EPC Stormwater

Re: *Ellicott School Addition 2 bldgs*
Project No. 61183
PCD File No. PPR2250

Final Drainage Report Comments Response

PHASE I RAIN GARDEN DETAIL

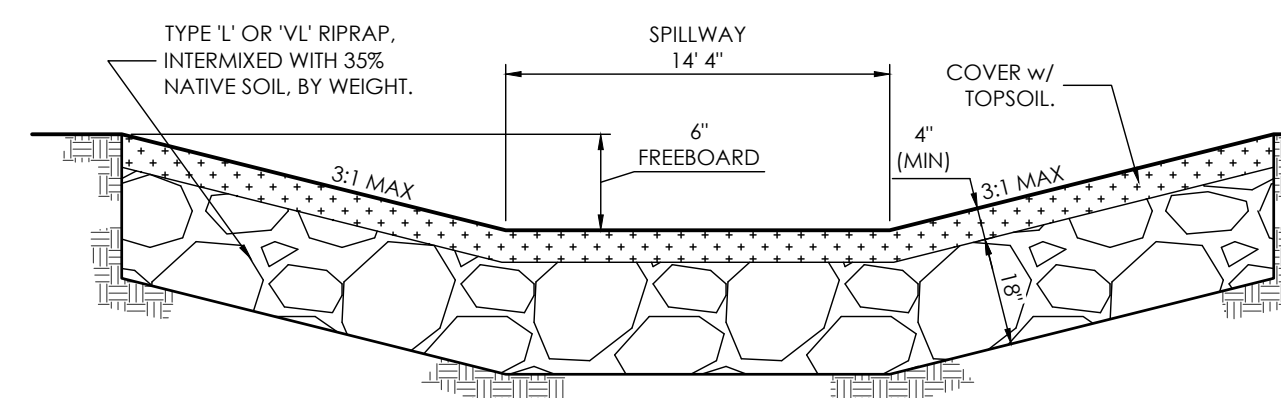
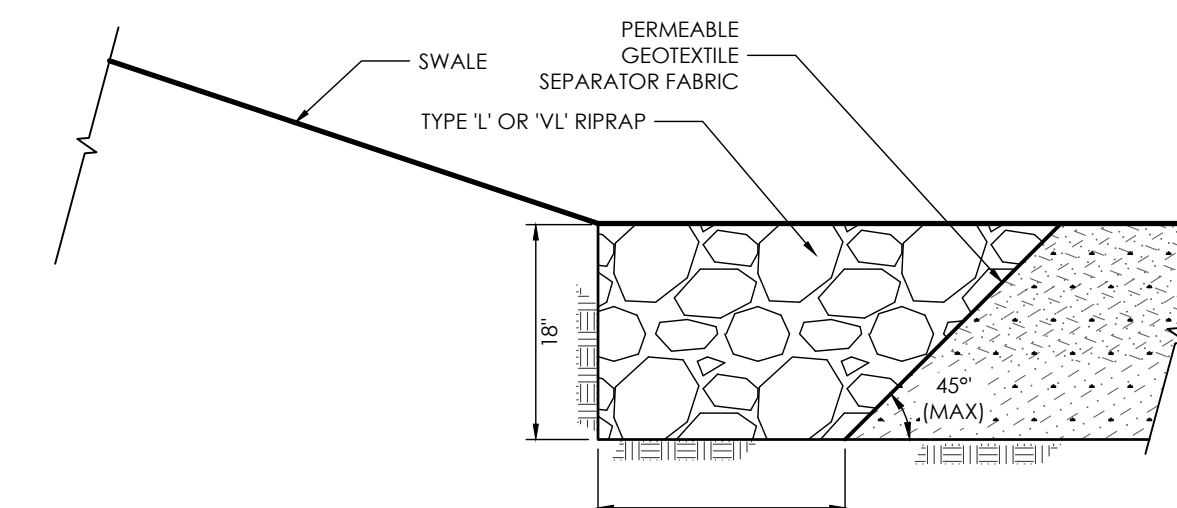
Also complete MHFD-Detention spreadsheets for each RG to show that drain times are acceptable and that the spillway is sized sufficiently for storms exceeding the WQCV event.

I saw that you completely the SDI Form (attached to MS4 Form and as separate docs in EDARP). But the form was not referenced in the report text above. Also, that form shows the drain times as being acceptable but doesn't provide spillway sizing calcs. Thus the MHFD-Detention spreadsheets are also needed. Unless you want to attach the SDI form to this report and do spillway calcs separately (on your own spreadsheet). Whichever way you want to do it is fine.

3. A statement about the SDI Forms and Spillway sizing calculations has been added to the Hydrologic Criteria section of the updated report, and SDI Forms as well as Spillway weir calculations for both rain gardens have been added to the Appendix.

A statement has been added to the FDR. SDI Forms and Spillway weir calculations have been added to the Appendix

**PHASE I**

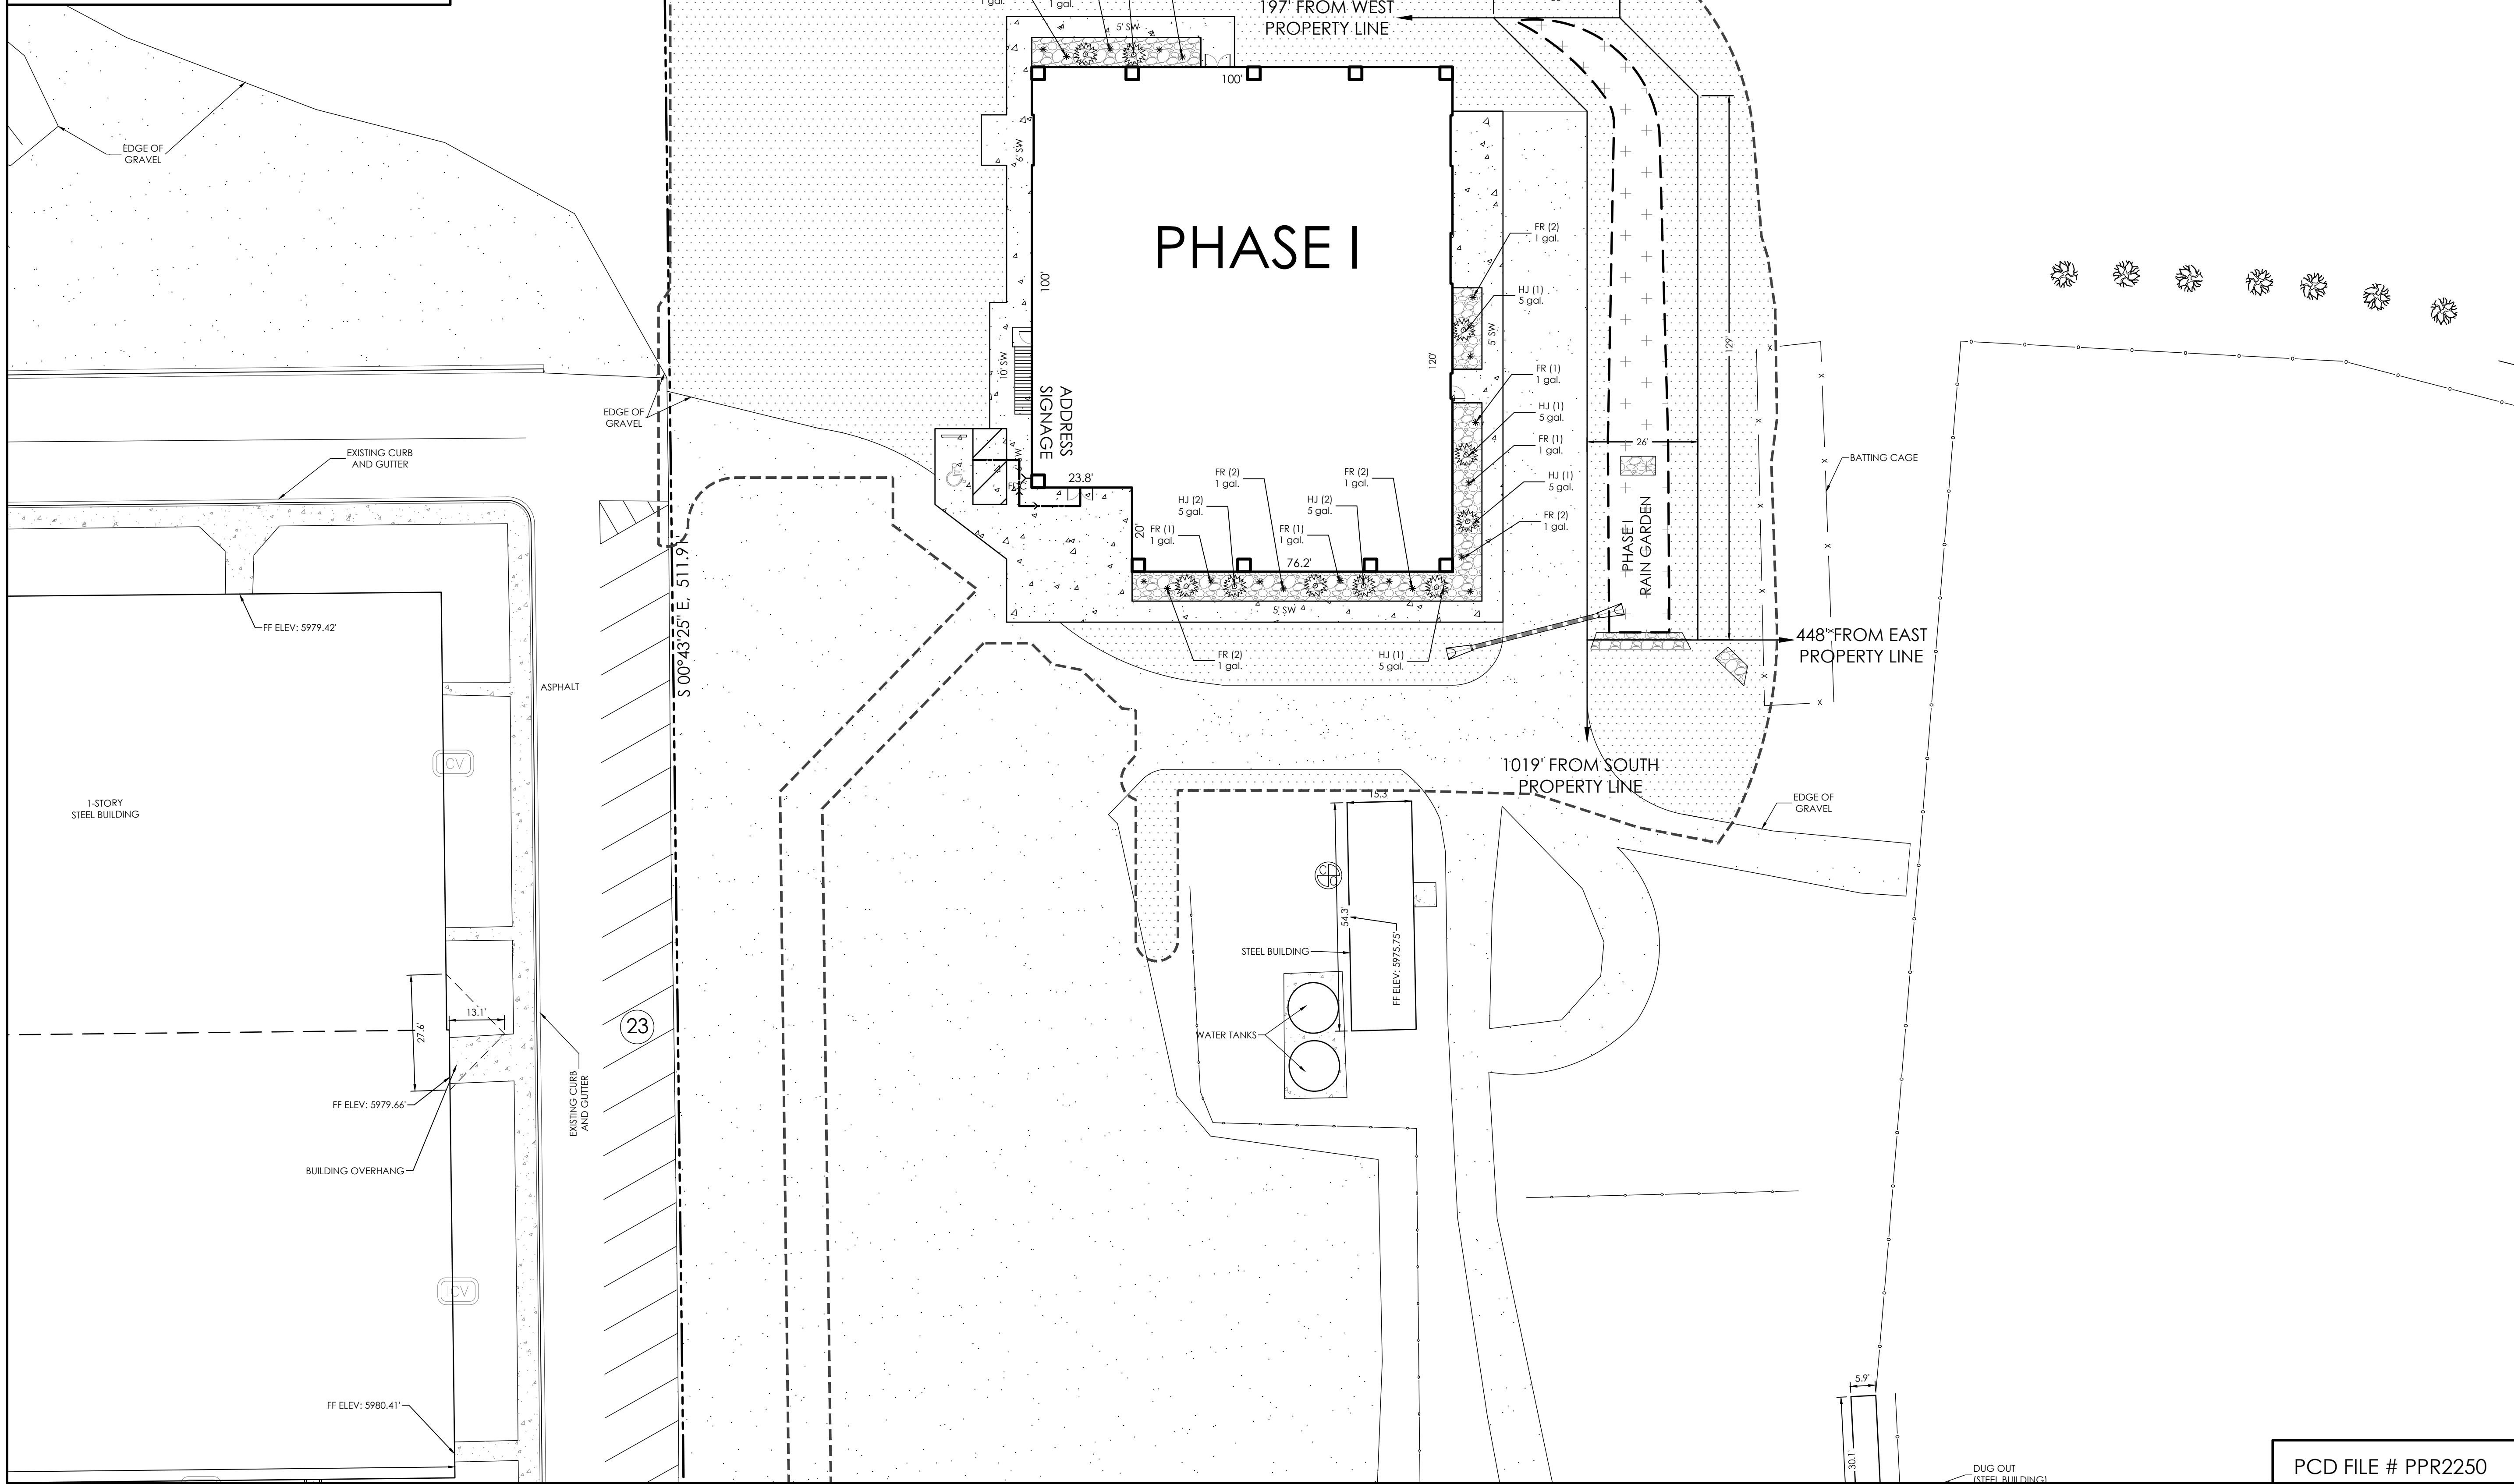
I agree with this statement but then all of the SPA's should be shown as receiving native seeding on the Landscape Plan, which they currently do not. Please update landscape plan accordingly.

2. Based on our phone call conversation, quantifying runoff reduction is not required if the WQCV Base Design standard is being used. Although runoff reduction practices are being employed as part of the four step process, only the WQCV Base Design standard is being used for water quality treatment for this site, utilizing the two proposed rain gardens. All statements mentioning the Runoff Reduction Base Design Standard have been removed from the updated report. Although no areas are now being assumed as SPA, all pervious disturbed areas will receive native seeding as shown on the Alternative Landscape Plan.

This statement has been removed along with all statements mentioning the runoff reduction base design standard. Runoff Reduction Standard is no longer employed, however, all pervious disturbed areas will receive native seeding as shown on the Landscape Plan.
